Cleve Hill Solar Park

DCO Application Reference EN010085

Written Representation from
Kent Wildlife Trust

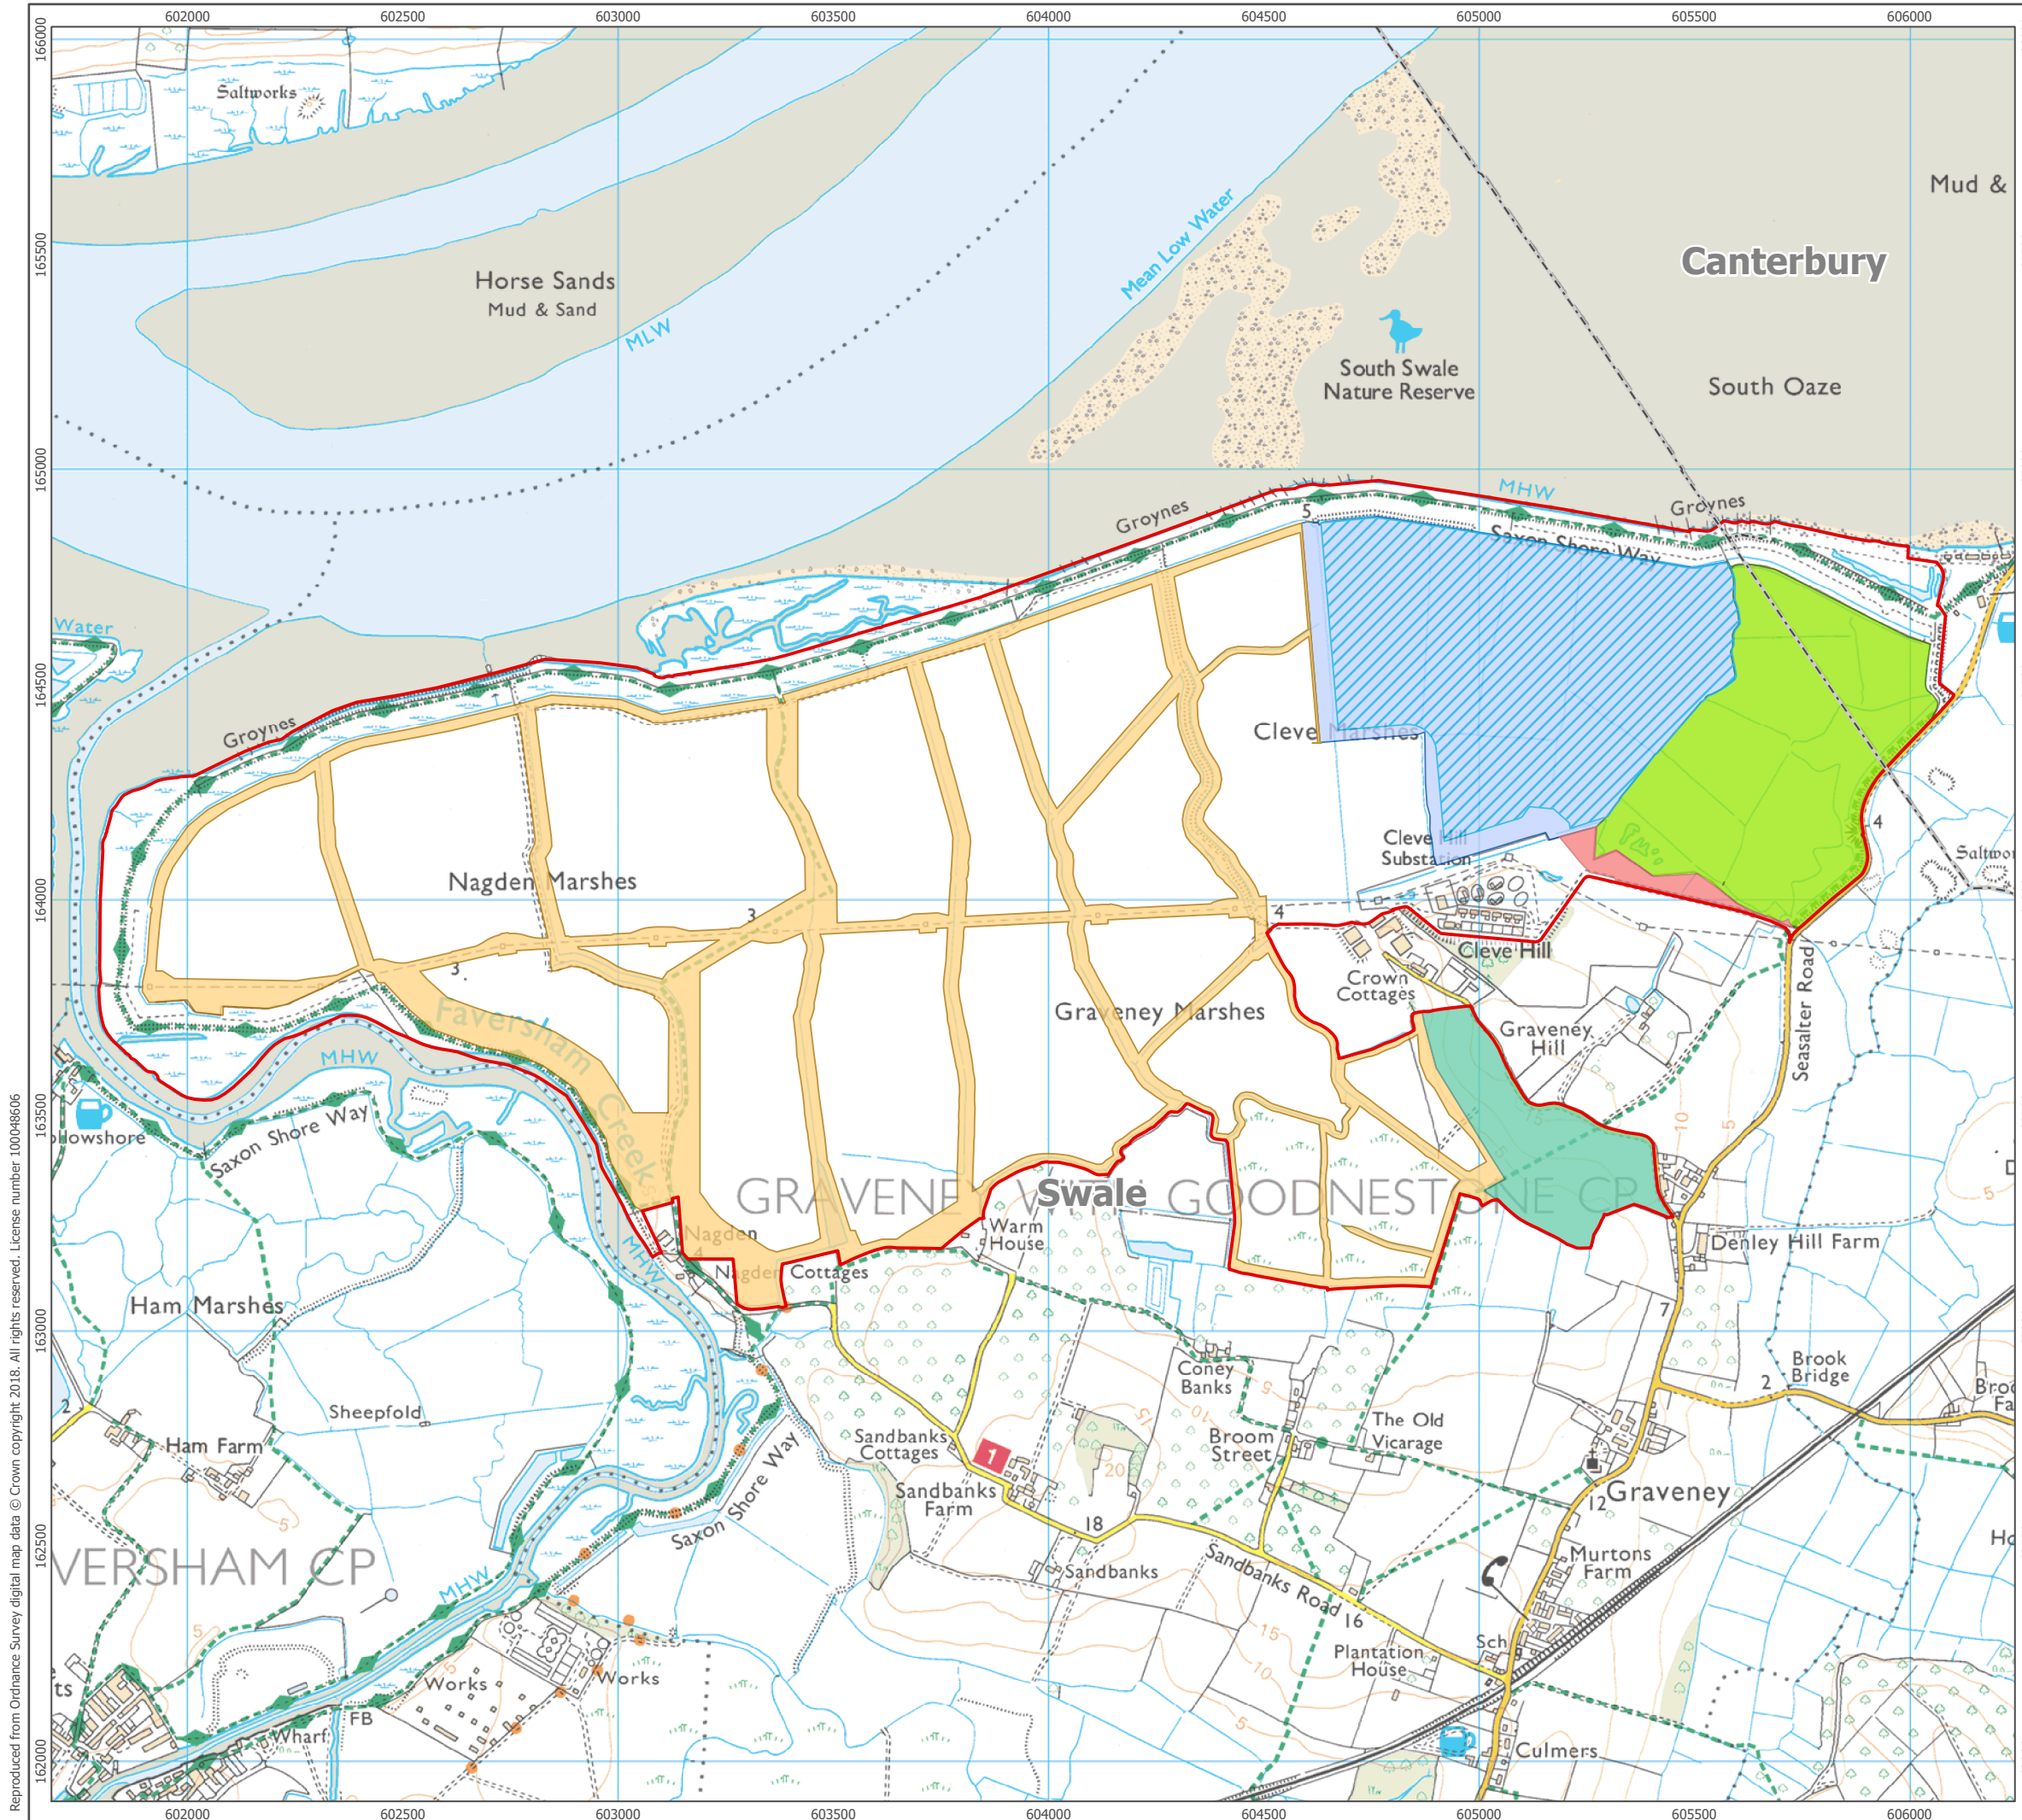
15. In particular, we would like to know how the Applicant proposes to control grazing densities within the perimeter fencing. At present, the LBMP treats the area within the perimeter fences as single compartments, but as can be seen from Habitat Management Areas figure (Figure 9.3 within APP-056) these areas can be divided into the ditches and buffers that are proposed to mitigate impacts on marsh harriers, and grassland under solar panels. It can be expected that outcomes between these two areas for any given grazing density (for the combined area) will be different, owing to the different growing conditions between them and behaviour of grazing stock. Another consideration is the prevention of poaching of ditch banks. We therefore consider it necessary to be able to control the grazing density between these areas separately. The provisions for grazing within the LBMP also need to be robust enough to avoid being compromised by commercial grazing interests.
